The Coal
Authority

PLANNING APPLICATION: 2021/62/93644/E

Erection and operation of grid-connected solar photovoltaic farm, with ancillary infrastructure and landscaping and biodiversity enhancements; Low Farm, Wakefield Road, Flockton, Huddersfield, Kirklees, WF4 4BB

Figure 4.1: Proposed Site Layout

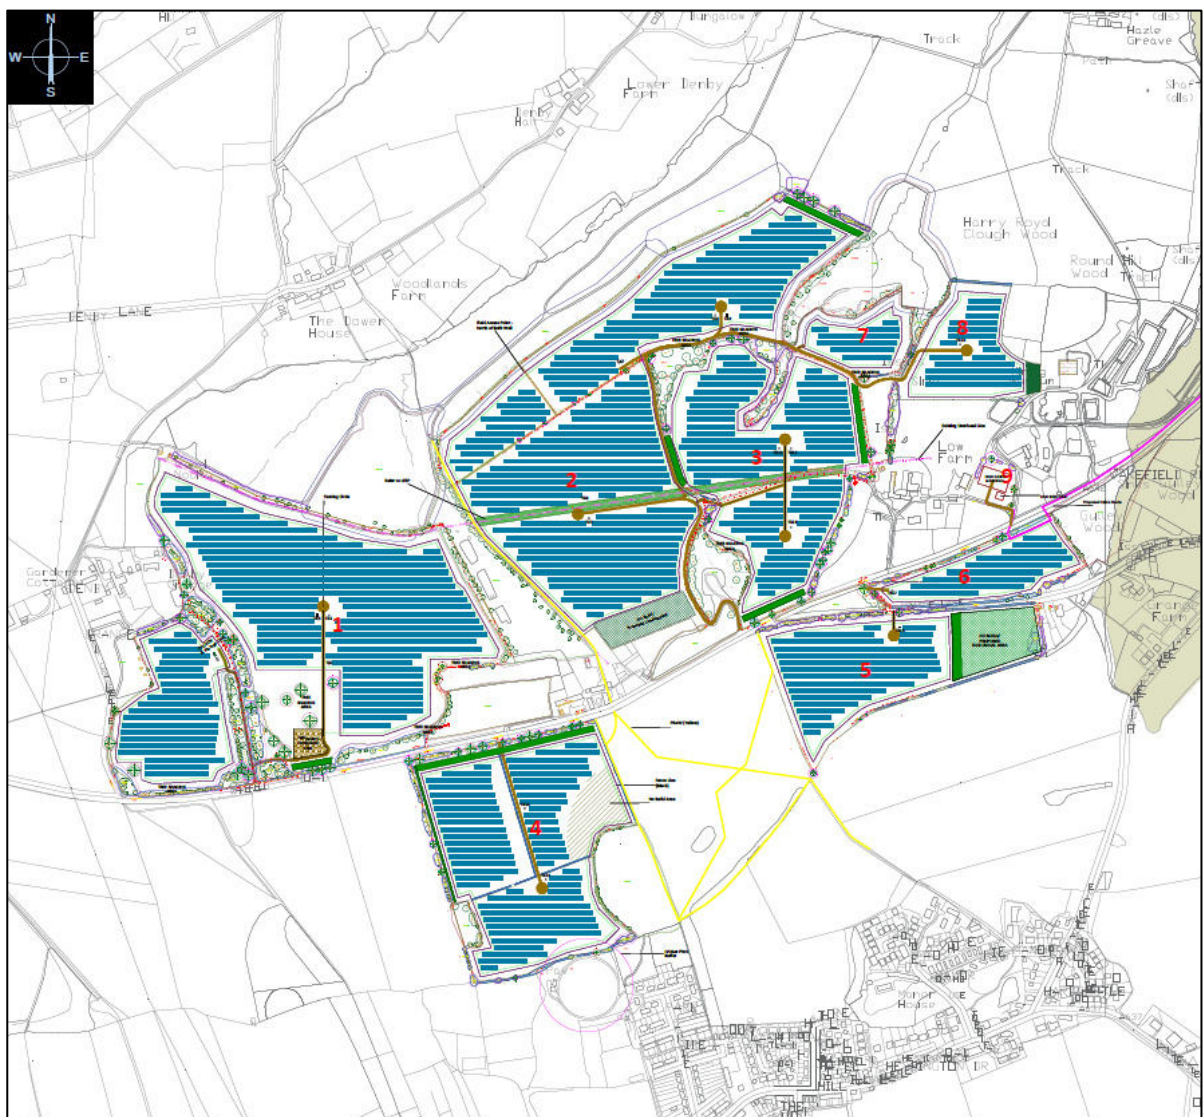
Whilst the Coal Authority concurs with the above, due to the presence of the recorded mine entries present, this may affect the layout of the solar panels, transformer stations and storage containers, within Areas: 3, 4, 5 and 6. Therefore, we consider it prudent that intrusive ground investigations, identified in Section 9.4.2 are carried out to confirm the exact location / condition of the mine entries. This will ensure that adequate separation is provided between these structures / transformer stations / storage containers and the mine entries. The applicant should be aware that if any mine entries are located and they have not been adequately treated, the responsibility for the treatment of these mining features is that of the developer.

b) any remediation works and/or mitigation measures to address land instability arising from coal mining legacy, as may be necessary, have been implemented on site in full in order to ensure that the site is made safe and stable for the development proposed. This should include the submission of the approved layout plan to illustrate the actual position of the recorded mine entries, if found present and calculated no build exclusion zones of each mine entry within influencing distance of the site.

a) a scheme of intrusive site investigations (Section 9.4.2 of the Preliminary Phase 1 Geo-environmental Assessment and Preliminary Coal Mining Risk Assessment, July 2021 prepared by WSP UK Ltd) has been carried out on site to establish the risks posed to the development by past coal mining activity, and;
